Application by Tritax Symmetry (Hinckley) Limited for an Order Granting Development Consent for the Hinckley National Rail Freight Interchange – Deadline 6 submission

Hinckley National Rail Freight Interchange

Leicestershire County Council Design Review Comments as presented to the Applicant team on 14.02.2024 and as discussed at a meeting with the Applicant team on 15.02.2024

Project - Originator - Zone - Level - Type - Role - Number	Status	Rev
HRF-BWB-HGN-HW06-DR-CH-0100	S2	P02

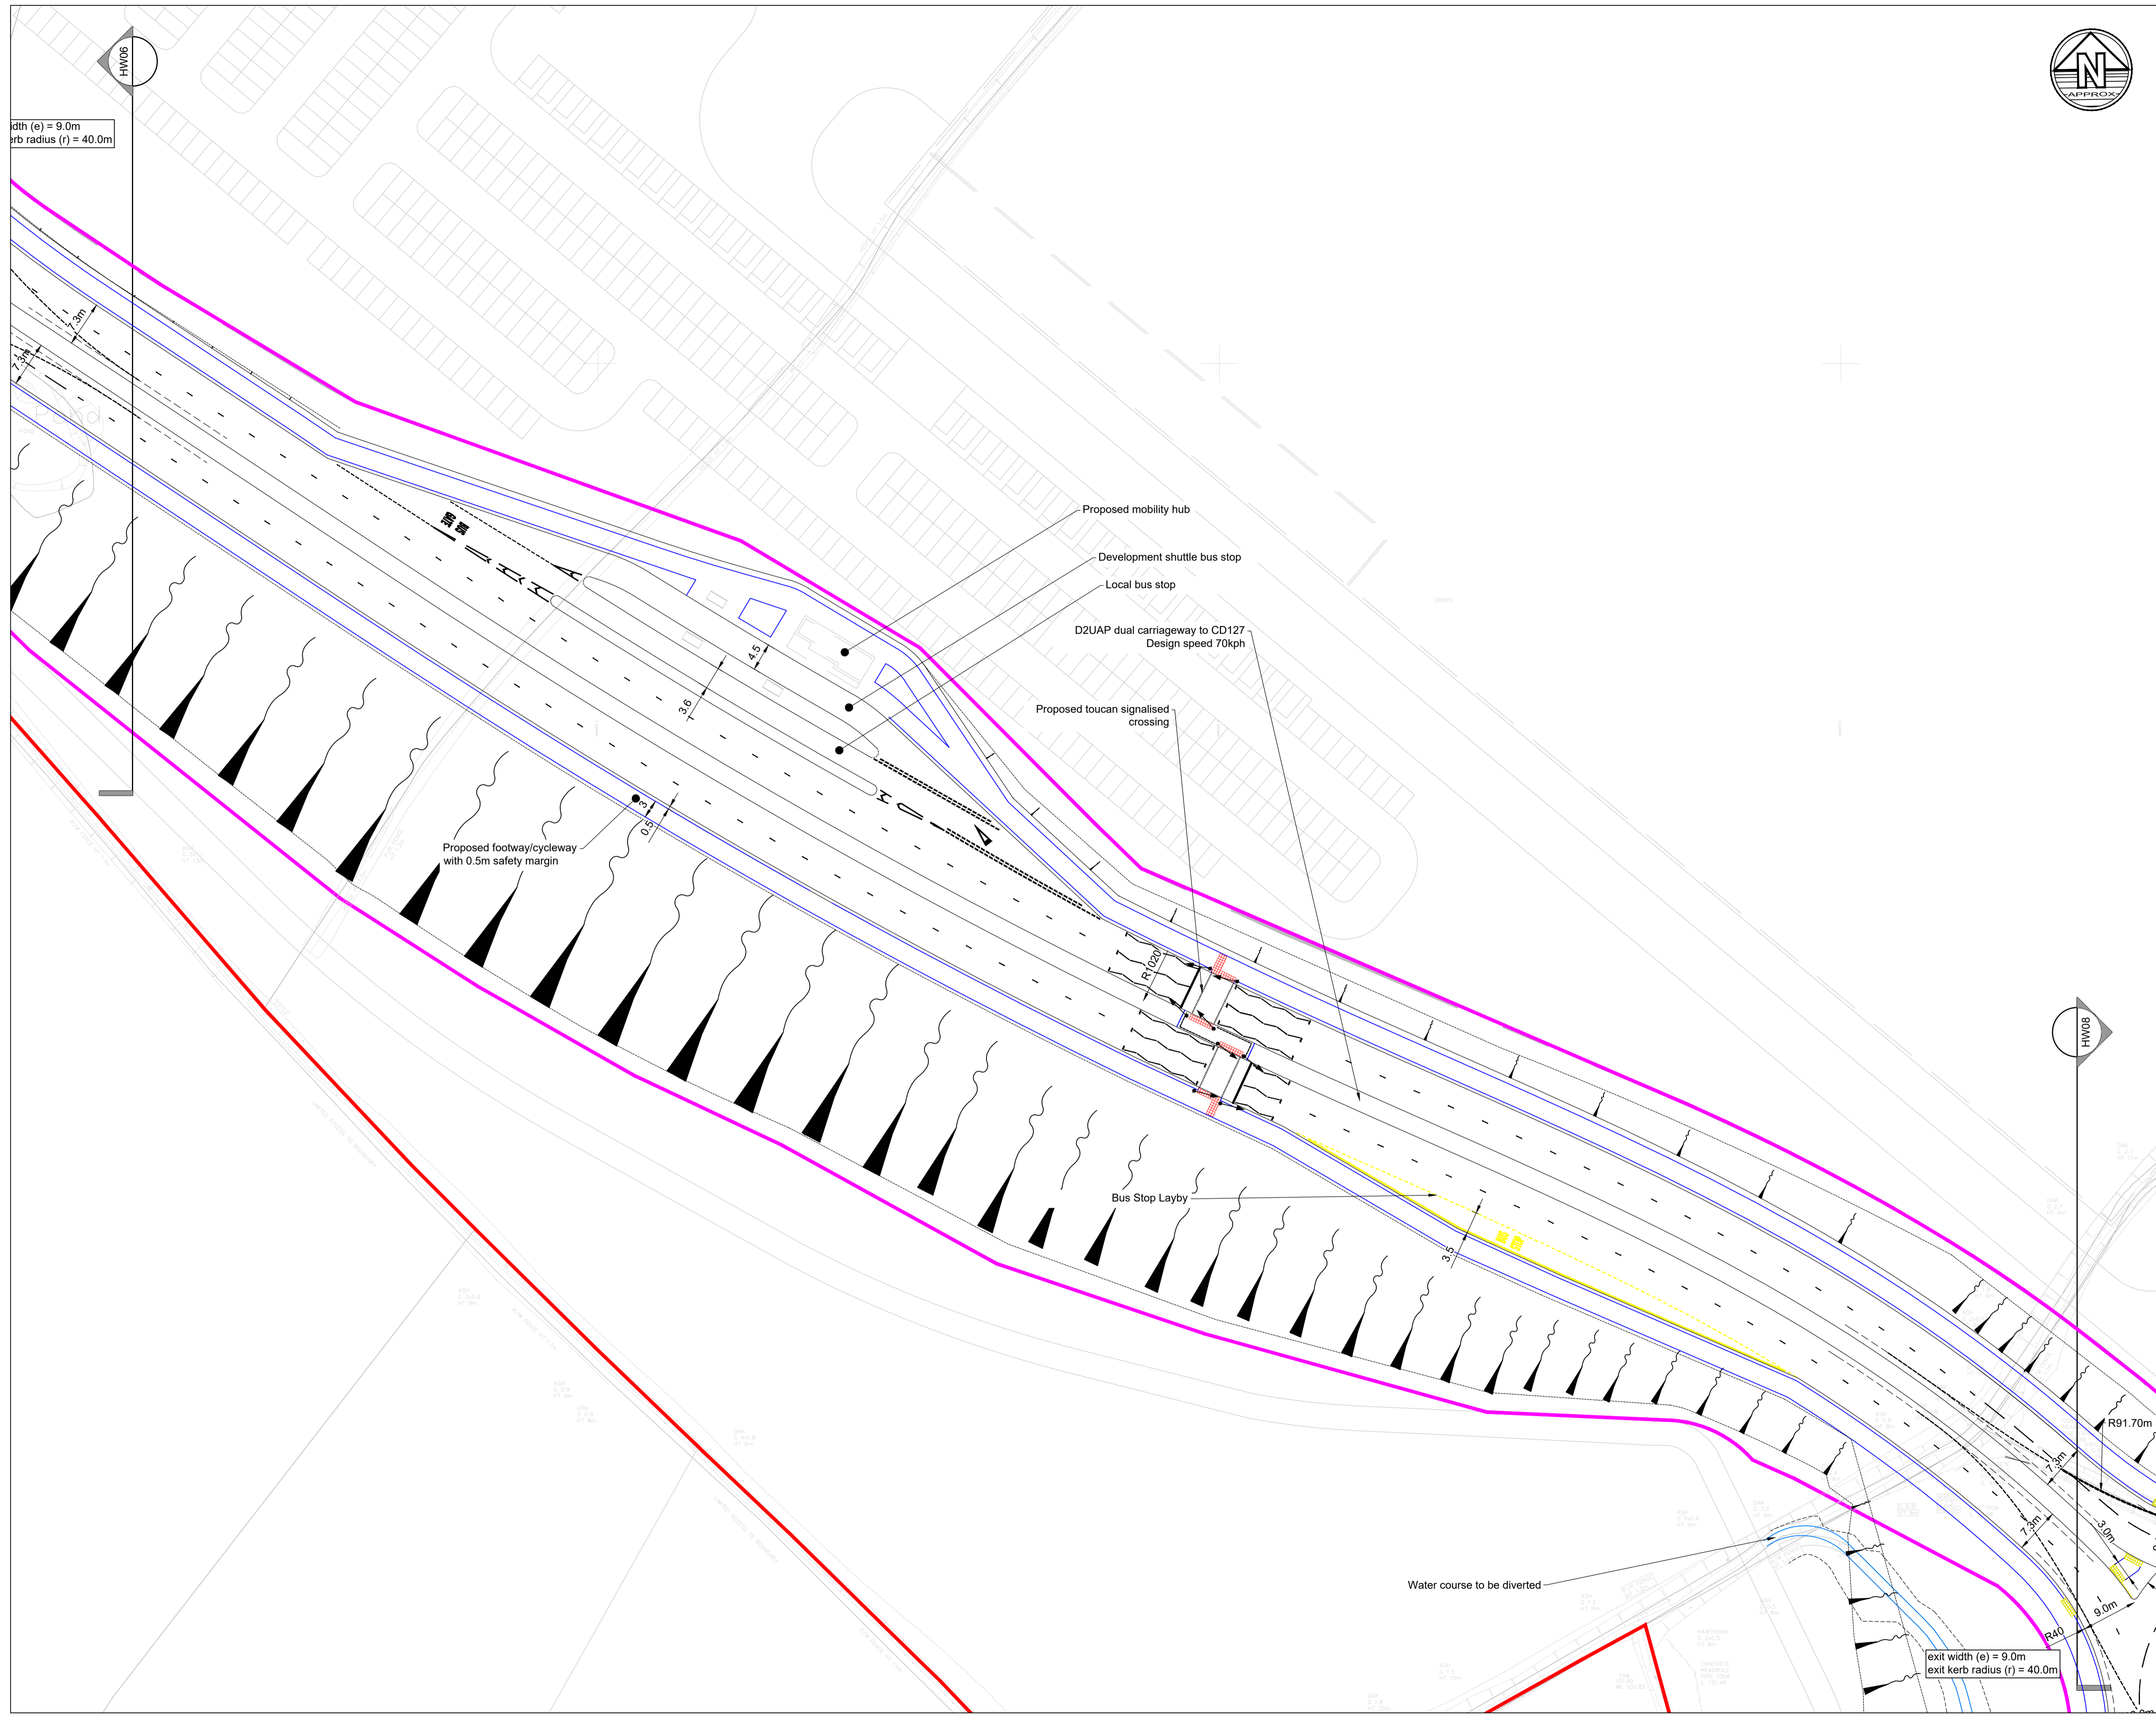
- 2.6.1 Approach visibility SSD to roundabout give way line needs to be shown to each arm.
- 2.6.2 Stepped accesses to bridleway to be removed.
- 2.6.3 Splitter Island layouts shown on South-West and North-East arms are incomplete.
- 2.6.4 Vehicle tracking analysis has been provided on Dwg No HRF-BWB-HGN-HW06-DR-CH-0115 and indicates multi-lane manoeuvres for the Max Legal Articulated vehicle. Tracking

appears acceptable although clarification required from the designer as to the speed setting used for the tracking analysis (to be advised on the drawing).

- 2.6.5 7.0m entry width on North arm means 10m wide circulatory area exceeds 120% ratio?
- 2.6.6 No drainage information provided with regards to the surface water on the proposed roundabout and the connected arms.

Drawn:	J.Manifold	Reviewed:	S.Carter
BWB Ref:	NTT2814	Date:	07.12.23
Scale@A1:	1:500	Status	Rev
PRELIMINARY			
Project - Originator - Zone - Level - Type - Role - Number	HRF-BWB-HGN-HW08-DR-CH-0100	S2	P02

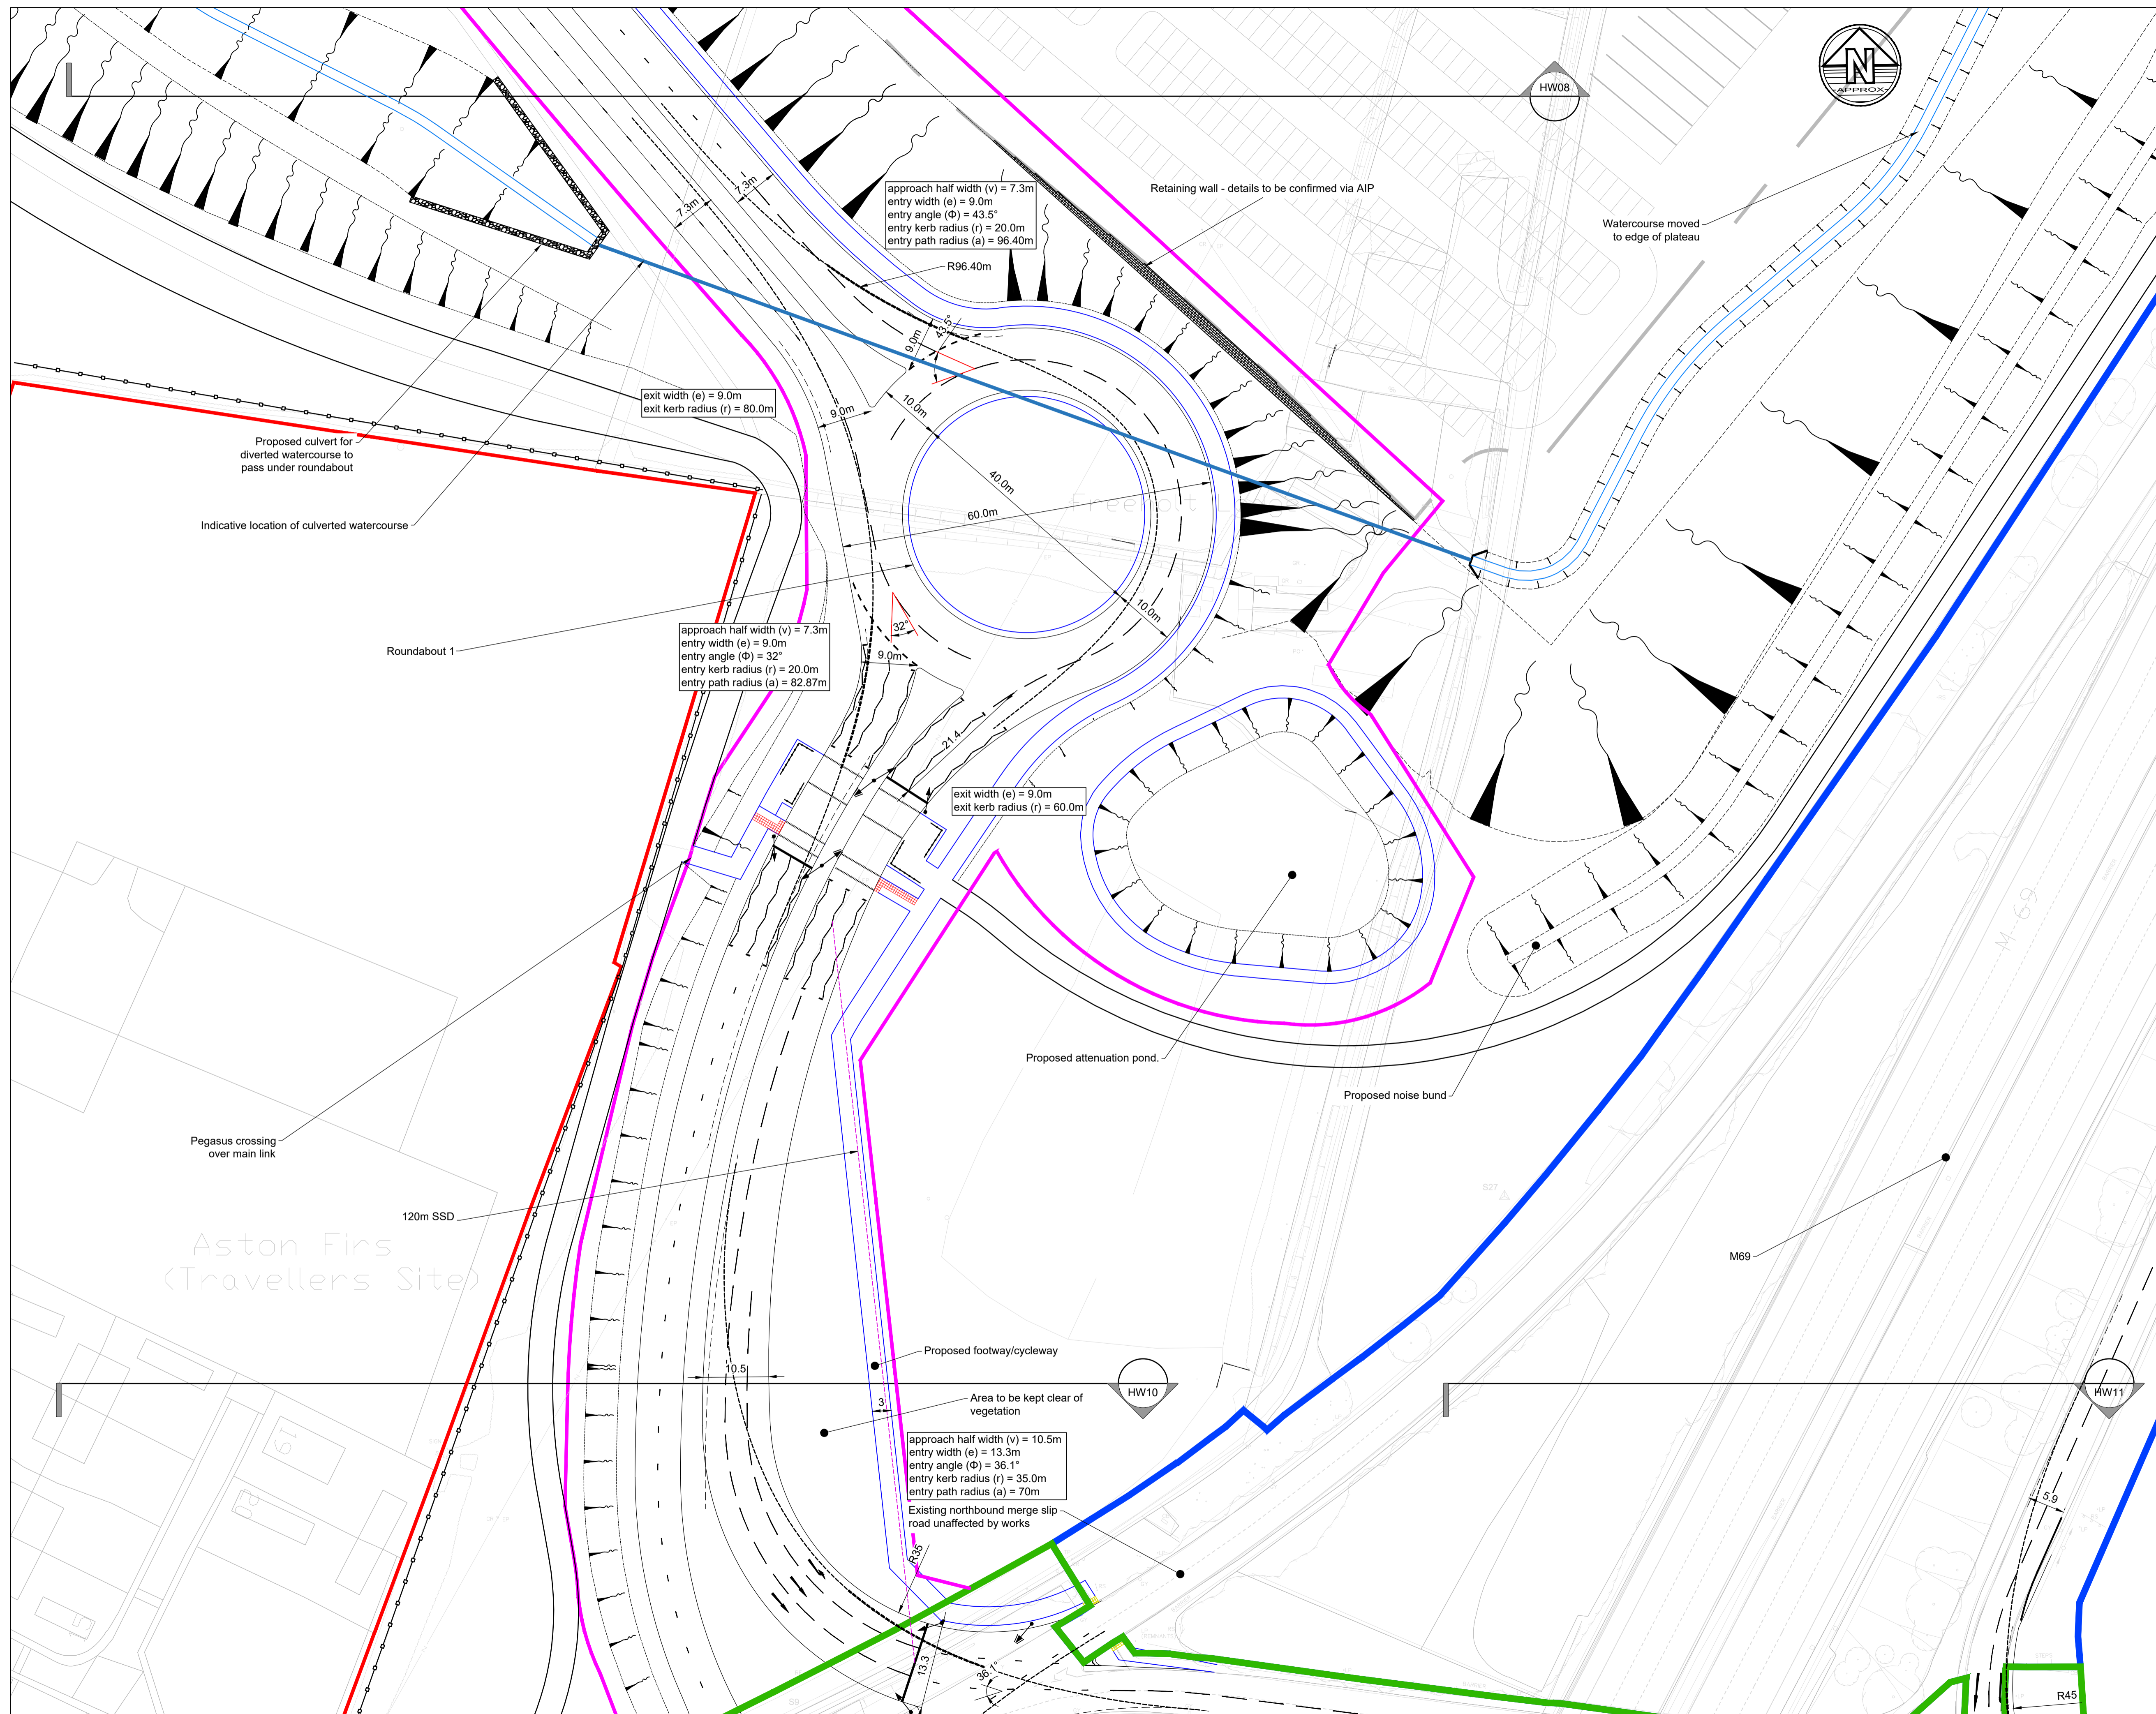
- 2.8.1 Central reservation width to dual carriageway to be indicated on drawing.
- 2.8.2 Concern regarding shared footway/cycleway provision adjacent to embankment provision. Fencing to protect against falls required.
- 2.8.3 Vehicle tracking has been provided on Dwg No HRF-BWB-HGN-HW08-DR-CH-0115 and indicates multi-lane manoeuvres for the Max Legal Articulated vehicle. Clarification required from the designer as to the speed setting used for the tracking analysis.
- 2.8.4 Additional verge width required adjacent to footway/cycleway unless retaining wall design is modified to reduce size of vertical drop.
- 2.8.5 There appears to be an access from the A47 link road to a building which is greyed out on the drawing? Clarification is required.
- 2.8.6 It is unclear why the section of footway/cycleway on the southern radii of the roundabout appears to be only 2m in width?

LCC Comment: Proposed crossing widths across splitter island and central reserve need to be shown on the GA drawing for each of the crossing locations to confirm that this has been suitably addressed.

Design Organisation Response: The designer agreed with RSA Recommendation and stated that all crossings on the link road have been reviewed to ensure the width of splitter islands and refuges is suitable.
